December 8, 2022

**Project Location: Arby's Site Development Plan @ South Academy Highlands
4456 Venetucci Boulevard
Colorado Springs, CO 80906**

This letter is in response to the comments received August 12, 2022 regarding the Arby's Site Development Plan application submitted on July 21, 2022.

A2.2 1/4" = 1'-0"

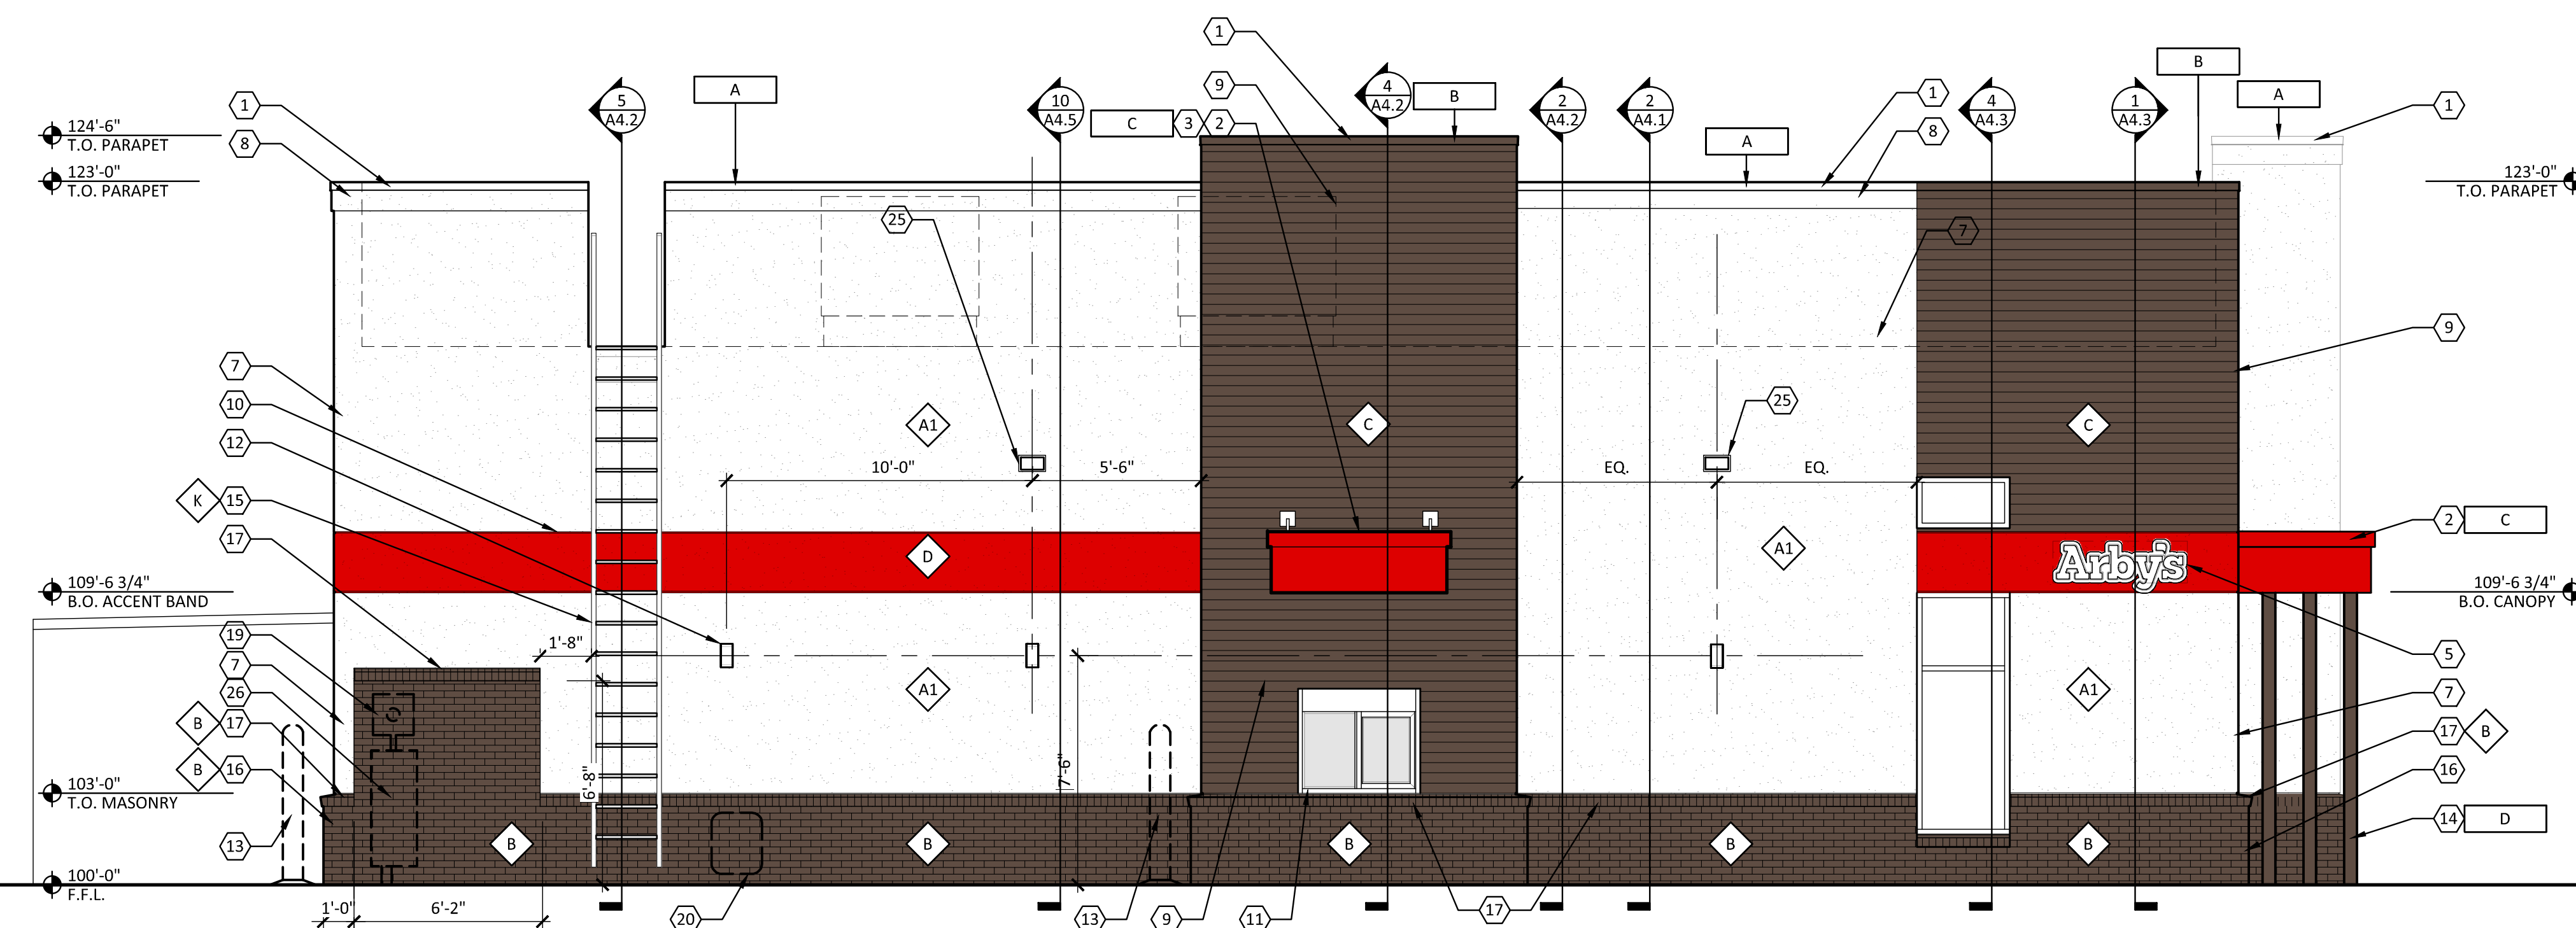
1. Please add the following note: Note: Signage is not reviewed as part of the site development plan and will require a separate sign permit application.

Response: The note has been added. See Sheet A2.1.

DESIGN KEY NOTES

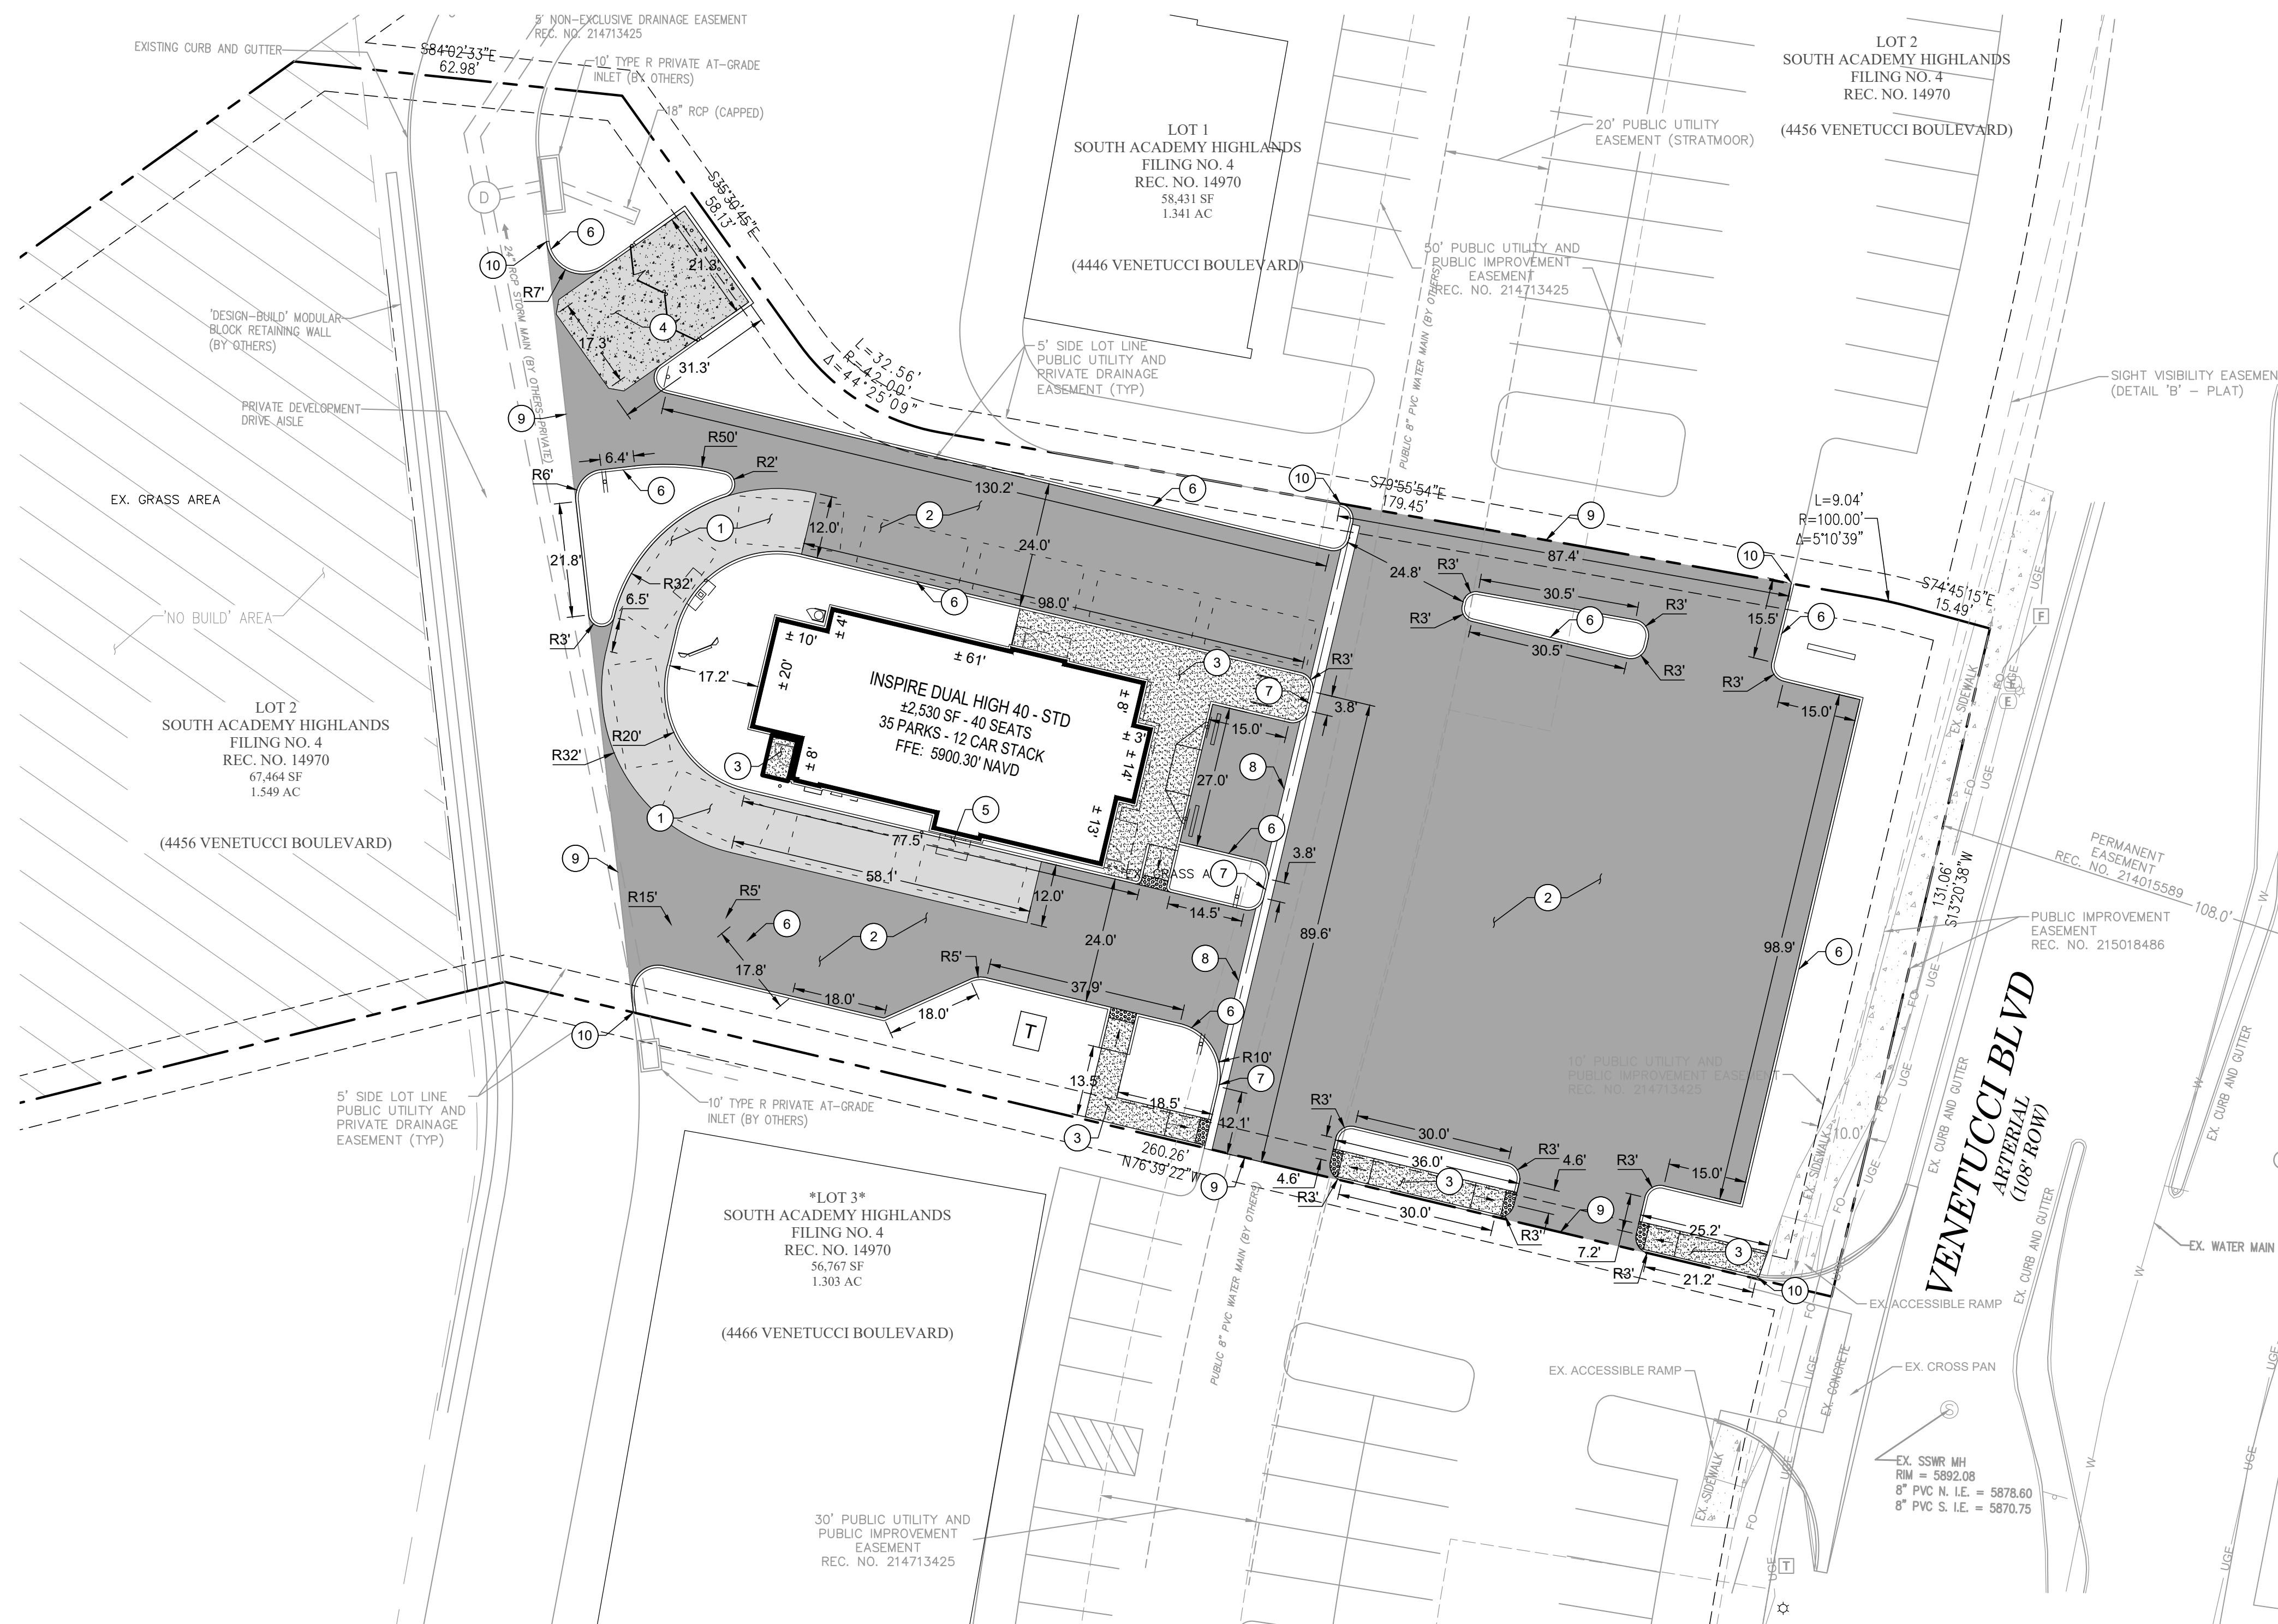
1. List the existing zoning of the property, PUD.

2. Please revise the lot lines to show the complete area of lot 2 recorded with South Academy Highlands Filing No. 4.

3. Remove the adjacent areas labeled as Tract J, Lot 8, Lot 7 and unplatted, these labels are no longer correct since the property has been replatted.

4. Show all easements that are noted on the final plat.

7. Please remove the front setback information from the site summary, this site is not abutting I-25, therefore no front setback is required, and this information is not necessary to include.

8. Please include the length and width of the building.

9. Please clarify the location of site plan design note 3. I am unable to locate this note on the plan.

11. Please include the height and screening material of the trash enclosure. Please note trash enclosures exceeding 6 feet in height require a building permit and must meet setbacks.

12. A loading space is required, please indicate on the plan the location of the loading space. If a separate loading space is not being provided, please include a note on the plan stating that all deliveries must take place outside of business hours.

13. Please label the dimensions of the stacking spaces and delineate the drive through lane from the private drive. Please clarify if these drives will be separated in any way.

15. Please show and label the bicycle parking, 5% of the required off-street parking is required.

17. The site summary lists the height of the structure as 23 feet. This does not match the height of the structure on the elevations sheet. The Fountain Zoning Ordinance states that building height must be measured from the average elevation of the finished grade to the highest point of the roof's surface. Please update the height to 24'6" on the site summary.

18. Please show the total site area of 1.549 in the site summary. You can remove the project area from the site summary.

19. Please show the length of the access picture below:

Response: The current zoning of the property has been listed as PUD (Planned Unit Development). Please see the Site Information section on sheet C-1 and the Site Summary Table on sheet C-7.

Response: The lot lines have been revised to show the complete area of Lot 2 South Academy Highlands Filing No. 4. Please see Site Plan on sheet C-7.

Response: All of the adjacent area labels (Tract J, Lot 8, Lot 7 and Unplatted) have been removed from the Civil Plan Set as requested. Please see sheet C-7'

Response: All easements have been updated to reflect the final plat. Please see sheet C-7.

Response: The front setback information has been removed from the site summary table. Please see the Site Summary on Sheet C-7.

Response: The length and width of the building have been included in the site summary table. Please see the Site Summary Table on Sheet C-7.

Response: Site Plan Design Note 3 (Pavement Markings (Drive-Thru)) has been added to the site plan. Note 3 has been added on the Site Plan to indicate the Pavement Markings (Drive-Thru). Please see Sheet C-7.

Response: The height and screening material of the trash enclosure has been added to the site plan. Please see Site Plan Design Notes, note 15 on Sheet C-7. See the Trash Enclosure Details on sheet C-16, Construction Details.

Response: A separate loading space has been provided on the Site Plan as requested. Please see sheet C-7.

Response: The dimensions of the stacking spaces (10' x 20') (TYP.) have been added to the Site Plan. The drive through lane has been delineated from the private drive and separated with pavement markings. Please see sheet C-7.

Response: Bicycle spaces have been provided as requested. Please see sheet C-7.

Response: The height of the structure has been revised to 24' 6" per the elevations. Please see Site Summary table on sheet C-7.

Response: The project area has been removed from the site summary and replaced with the total site area of 1.549 acres. Please see Site Summary table on sheet C-7.

Response: The length of the drive aisle has been added to the drawing as requested. Please see sheet C-7.
